Our Ref: WA/53/20/NMA

**Section 96A of the Town & Country Planning Act 1990 (as amended)
Town and Country Planning (Development Management Procedure) (England) Order 2015 (as amended) - Article 10**

Non material amendment following grant of WA/36/20/HH for the increased width of proposed kitchen and reduced width of proposed study.

Murroes Dairy Lane Walberton BN18 0PT

project: 20/C05
drawing no: 3c
date: March 2020

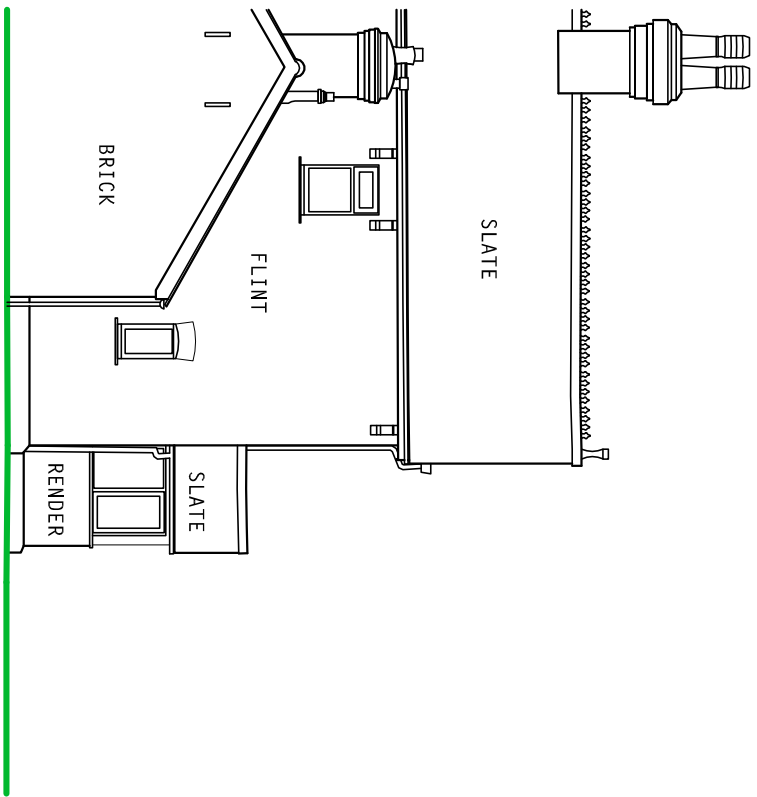
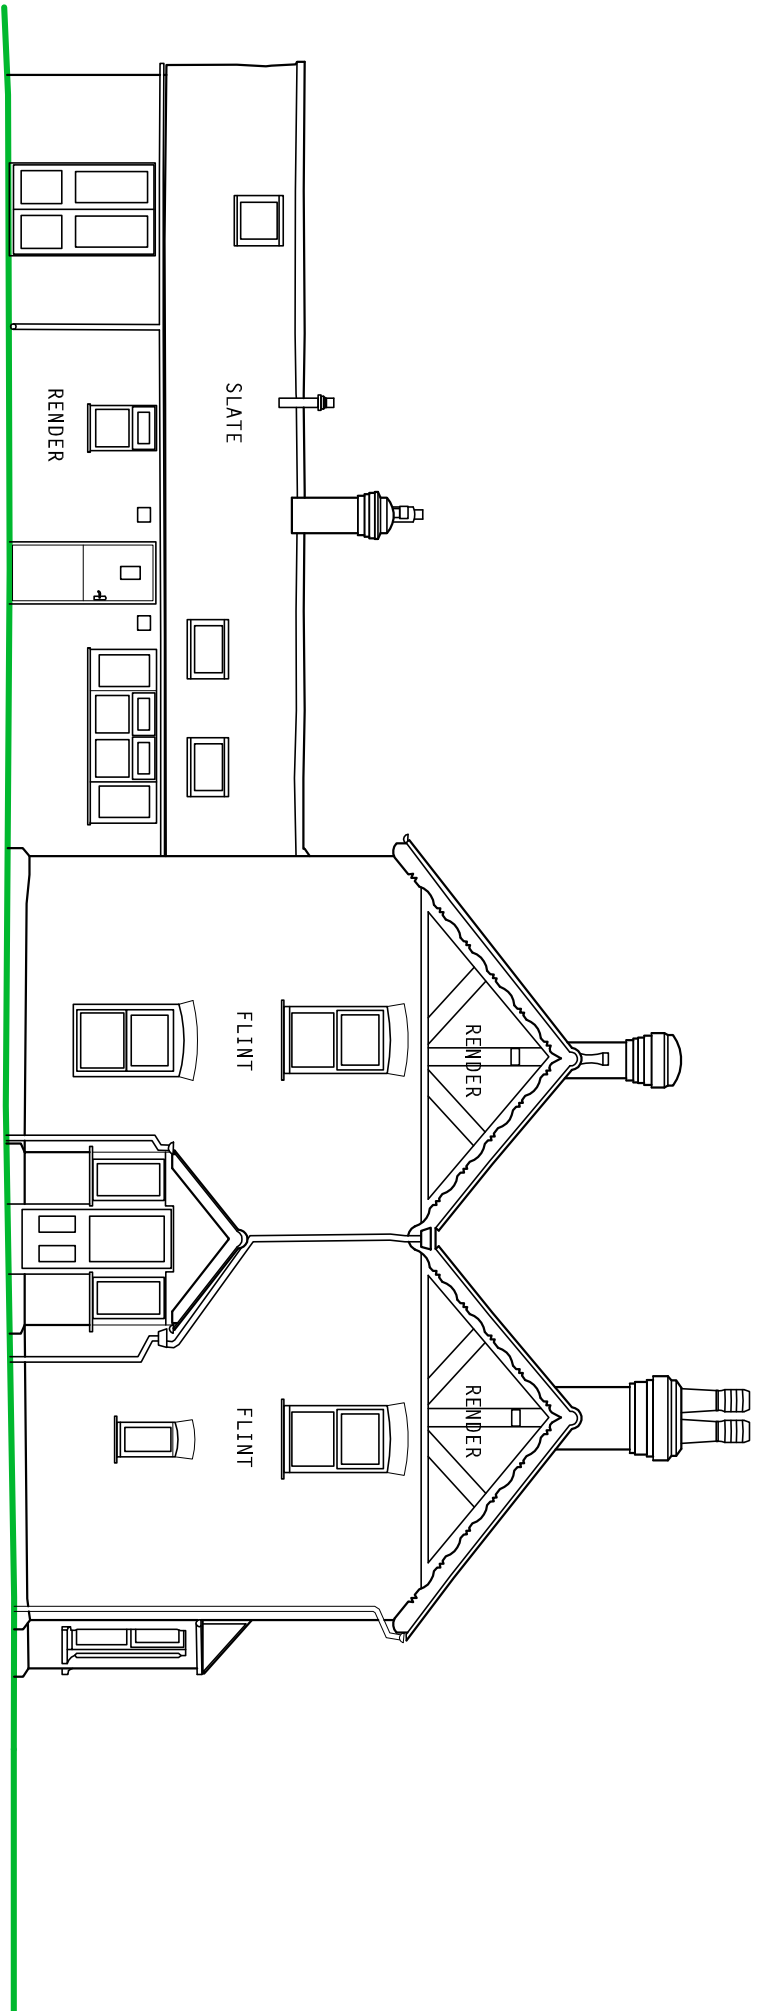
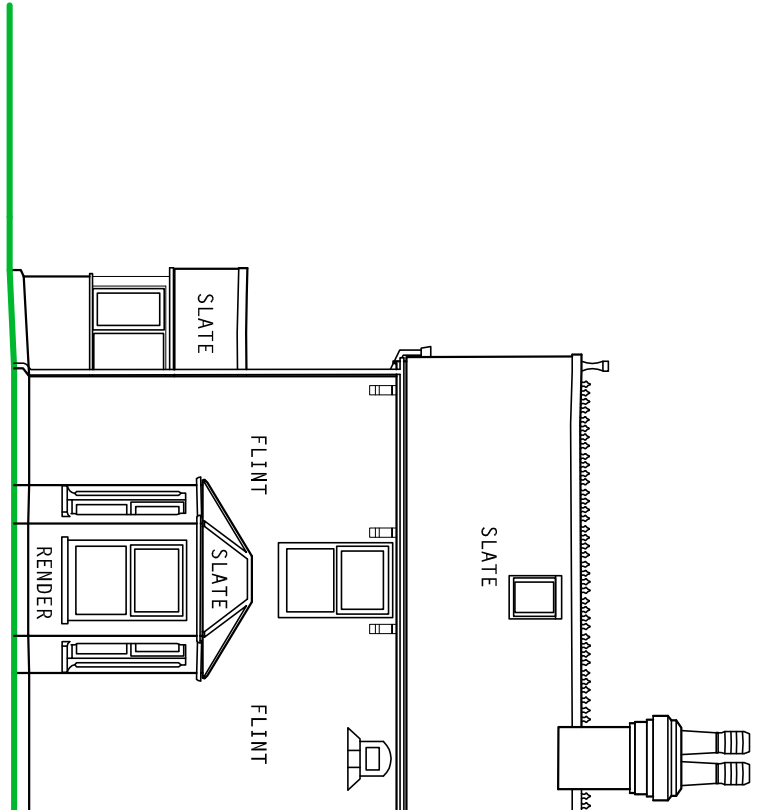
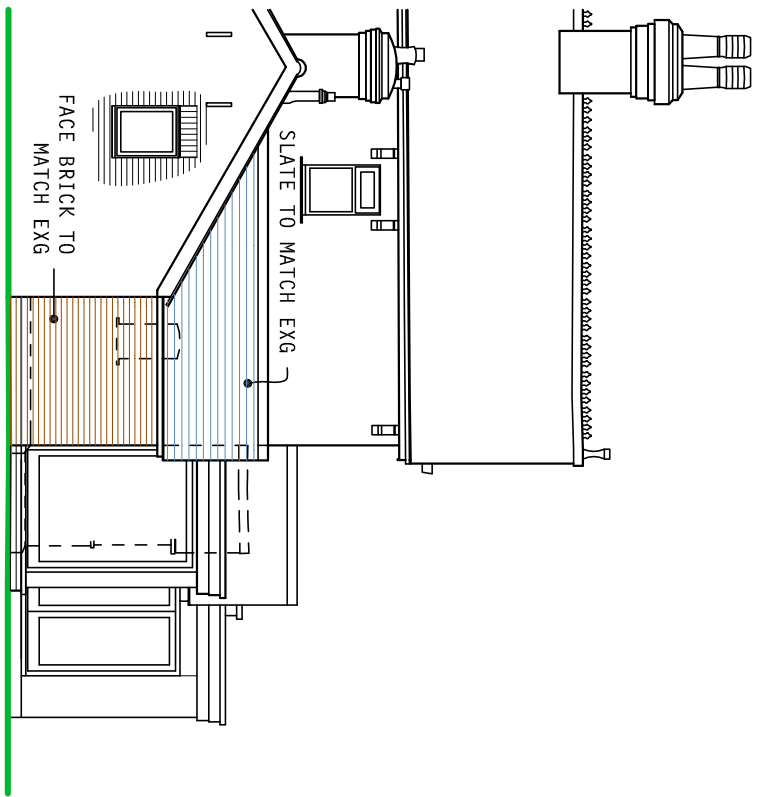
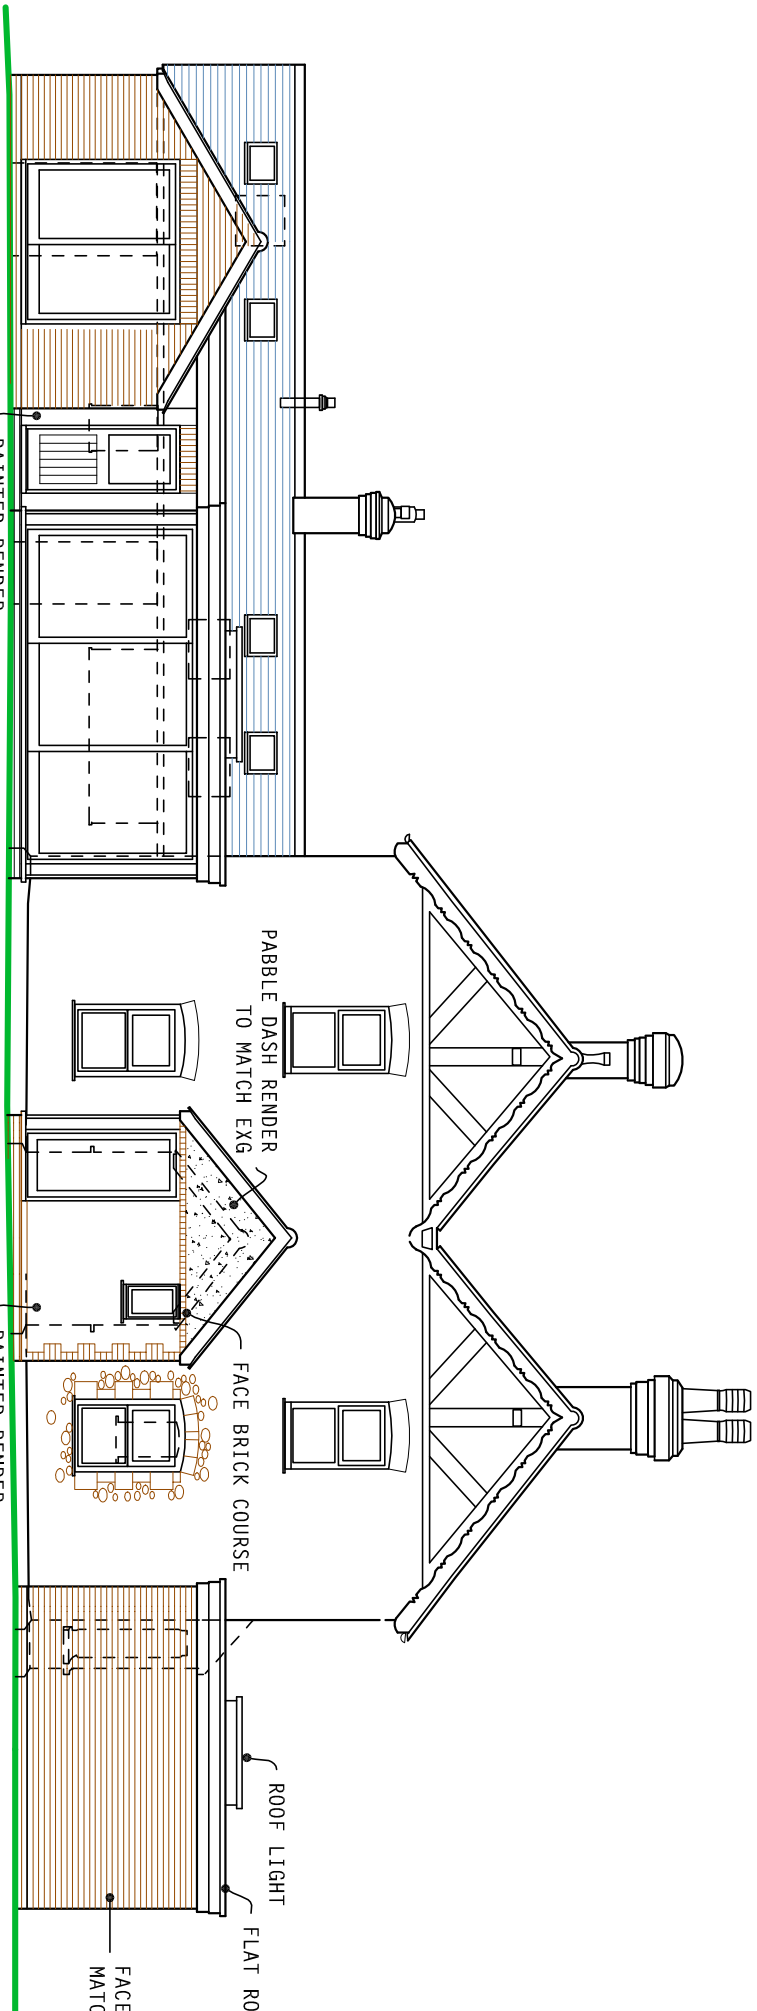
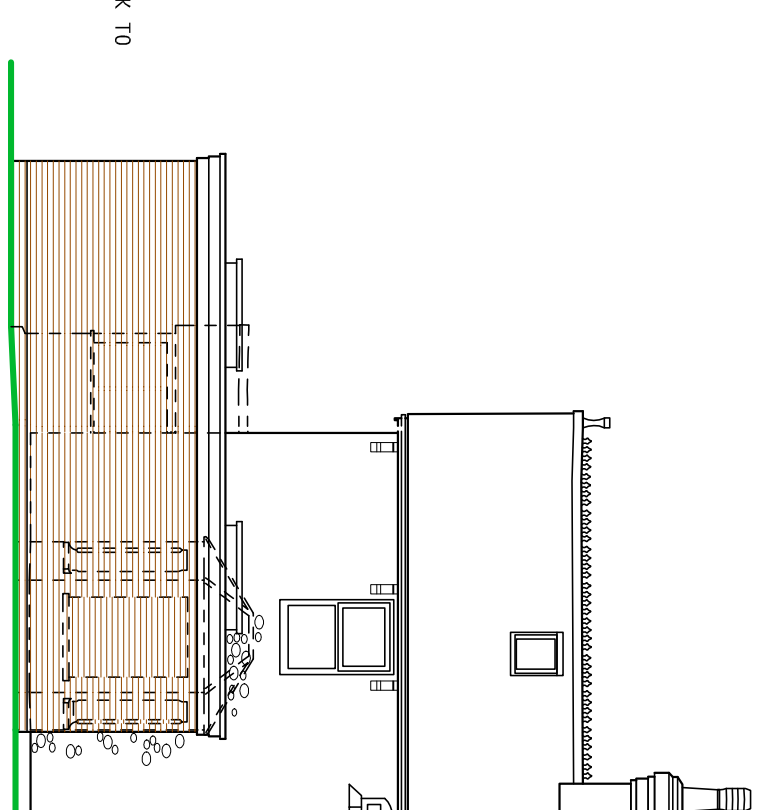
I refer to your recent application for a Non Material Minor Amendment. I understand that you wish to increase the width of the kitchen by 0.7m, and reduce the study width by 0.7m.

The approved plans 'Plans - 20/C05 - 3b - March 2020' and 'Plans - 20/C05 - 2c - March 2020' are hereby replaced by 'Plans - 20/C05 - 3c - March 2020' and 'Plans - 20/C05 - 2d - March 2020'.
